Application no: H22/0628/99

Description: Erection of a 3 bedroom
bungalow

Location: Plot 3, Broadgate
Weston
Spalding
Lincs

Amendment: Change bricks to Desimple - Mid Summer Yellow

DRAWING No.: DGM-W.3

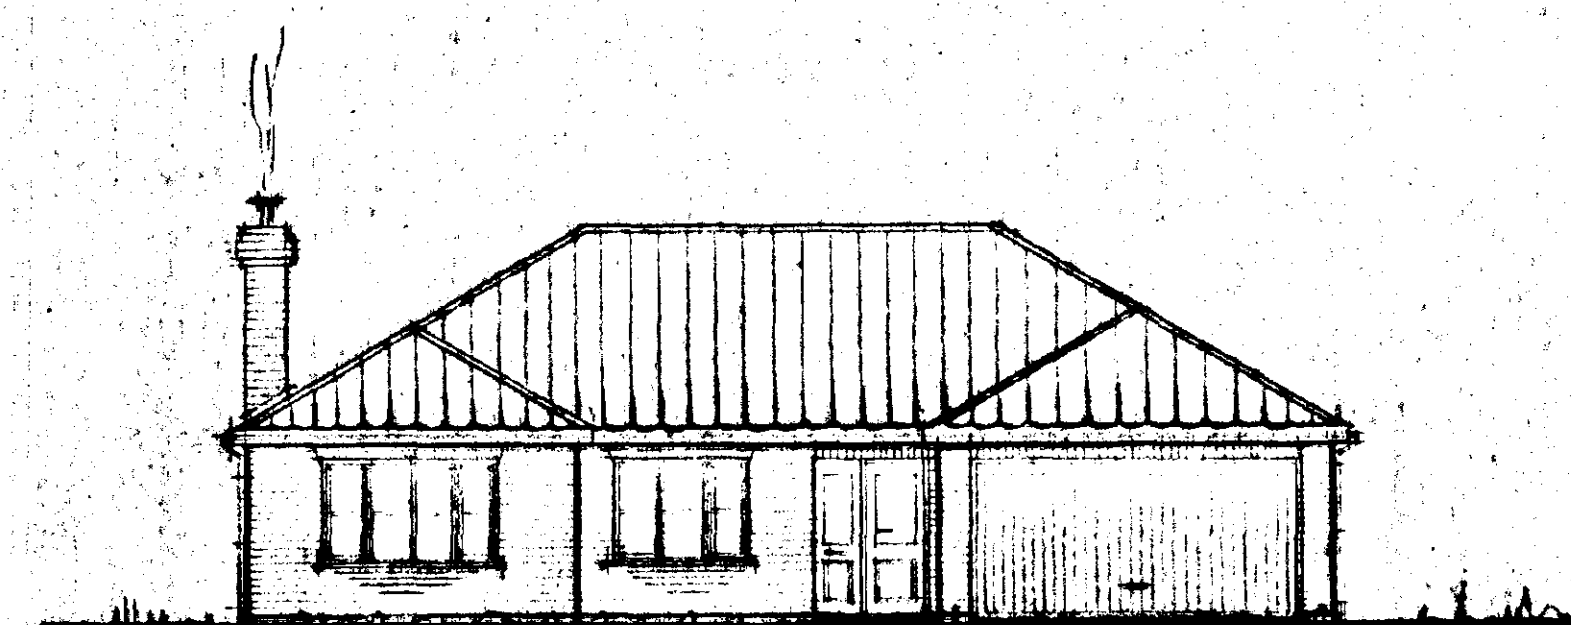
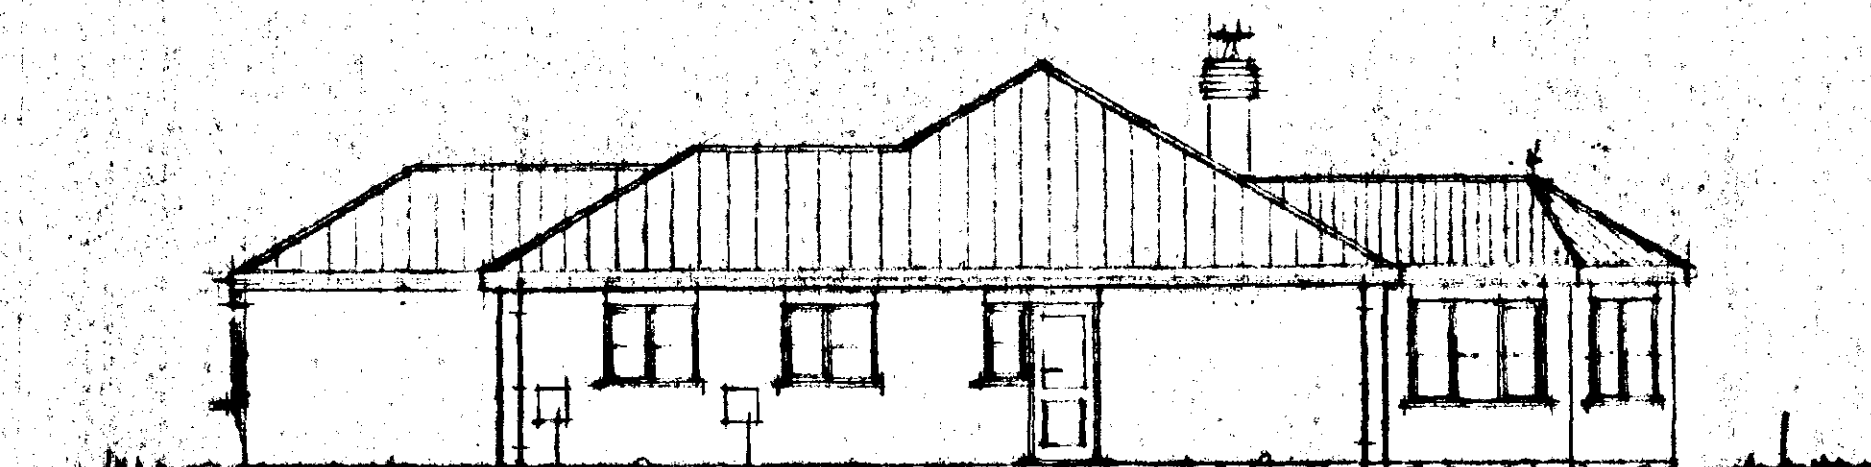
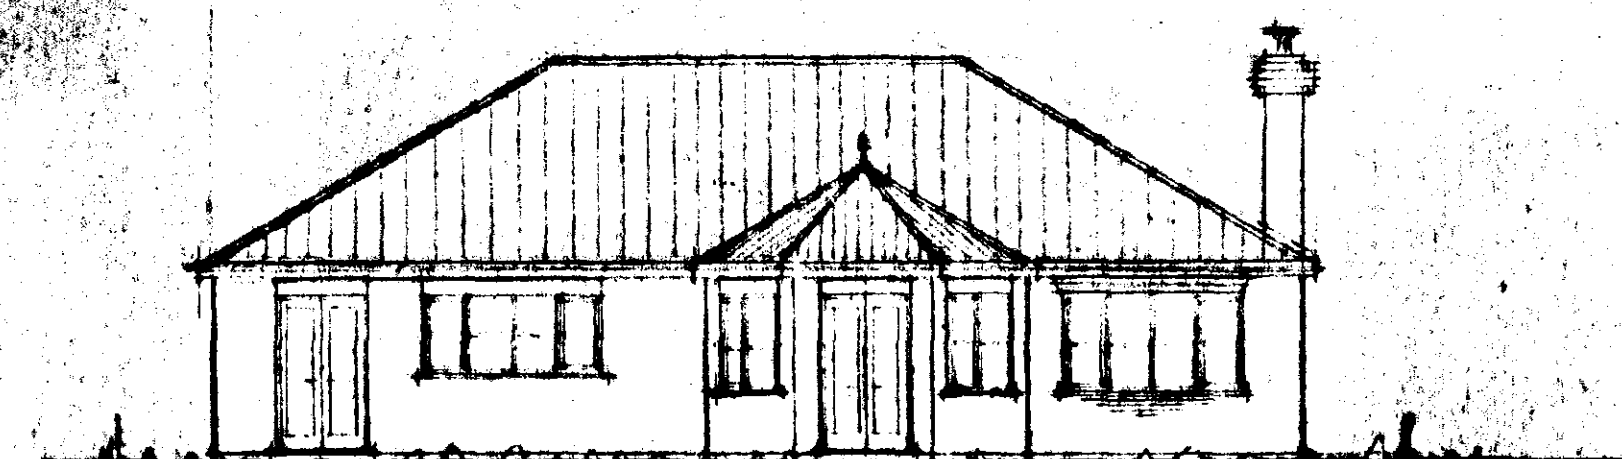
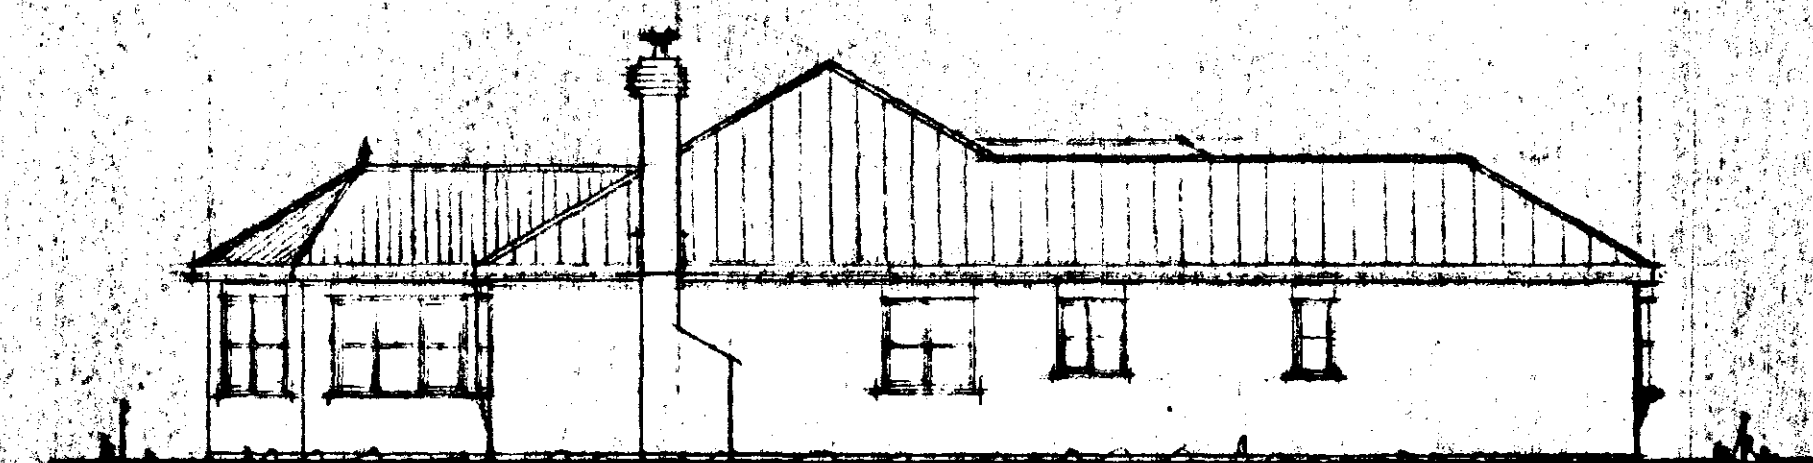
change Bricks
to - Desimple -
red Summer
yellow

The amended details submitted in respect of the above proposal have now been considered and there are no objections to the amendment being implemented to the extent described above.
